Department for Transport

**APPLICATION FOR NON-MATERIAL CHANGES TO THE M25 JUNCTION 10/A3
WISLEY INTERCHANGE DEVELOPMENT CONSENT ORDER 2022 (S.I. 2022 NO.
549), AS CORRECTED BY THE M25 JUNCTION 10/A3 WISLEY INTERCHANGE
DEVELOPMENT CONSENT (CORRECTION) ORDER 2023 (S.I. 2023 NO. 46)**

Project Title	M25 JUNCTION 10 / A3 WISLEY INTERCHANGE IMPROVEMENT
Drawing Title	SPEED LIMITS AND TRAFFIC REGULATIONS PLANS REGULATION 5(2)(o) SHEET 4 OF 9
Drawing Number	HE551522
Project	BBA - LDC - WHL_ML_A3 - DR - ZL - 020704
Location	A1
Scale	1:2500
Project Ref. No.	5195939
Sheet	4 of 9
Rev	P02

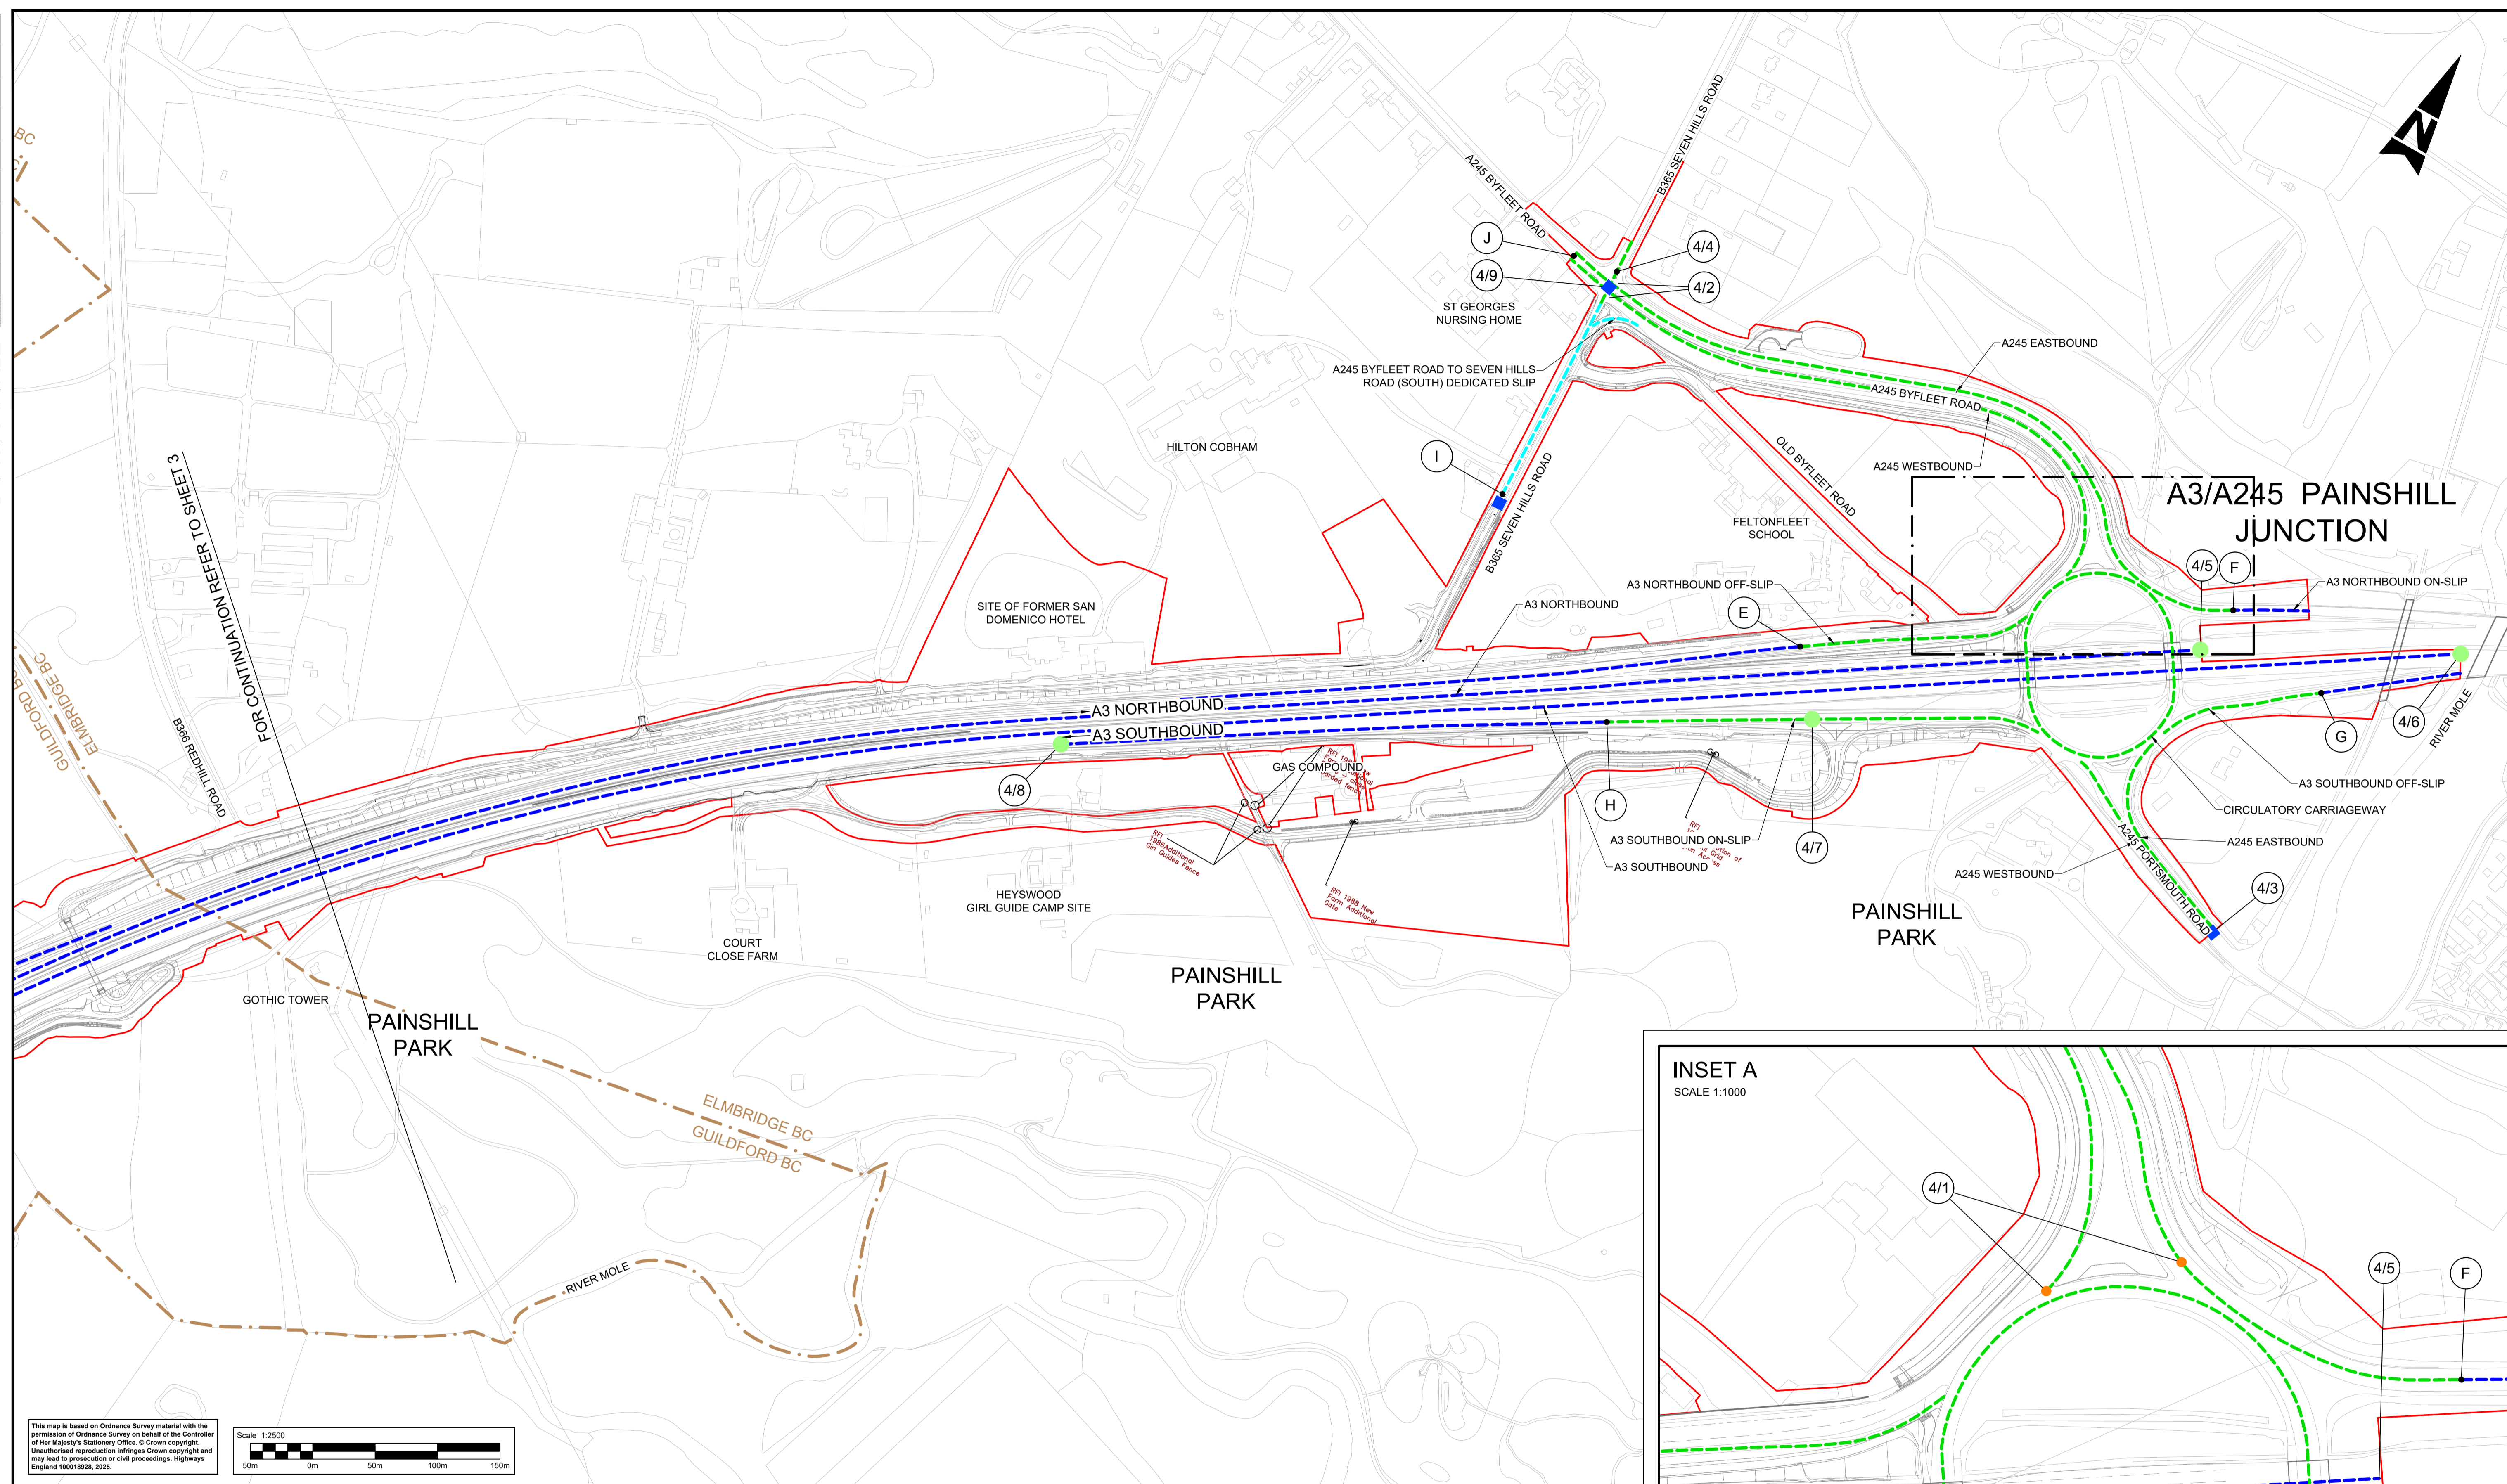
- Introduce variable speed limits on the M25 main carriageway and its slip roads at Junction 10. This will allow the safe and efficient operation of the road network by ensuring that the fixed speed limit provisions authorised by the Order, do not conflict with the variable speed limits for the M25 as prescribed under the [M25 Motorway \(Junctions 7 to 16\) \(Variable Speed Limits\) Regulations 2012](#);

- Amend the Order to reflect that works to the A3 northbound to A245 westbound slip lane at Painshill junction (the “jet lane”) are no longer going ahead and are not included in the authorised Development, following a design change approved by the Secretary of State under requirement 5 of the Order on 28 February 2024. This change simply seeks to remove the road from the list of roads in Part 5 of Schedule 3 to the Order with prescribed speed limits; and

- Update the relevant Speed Limits and Traffic Regulations Plans listed in Schedule 11 to the Order (sheets 3, 4, 5, 6, 7 and 9) to reflect the above changes.
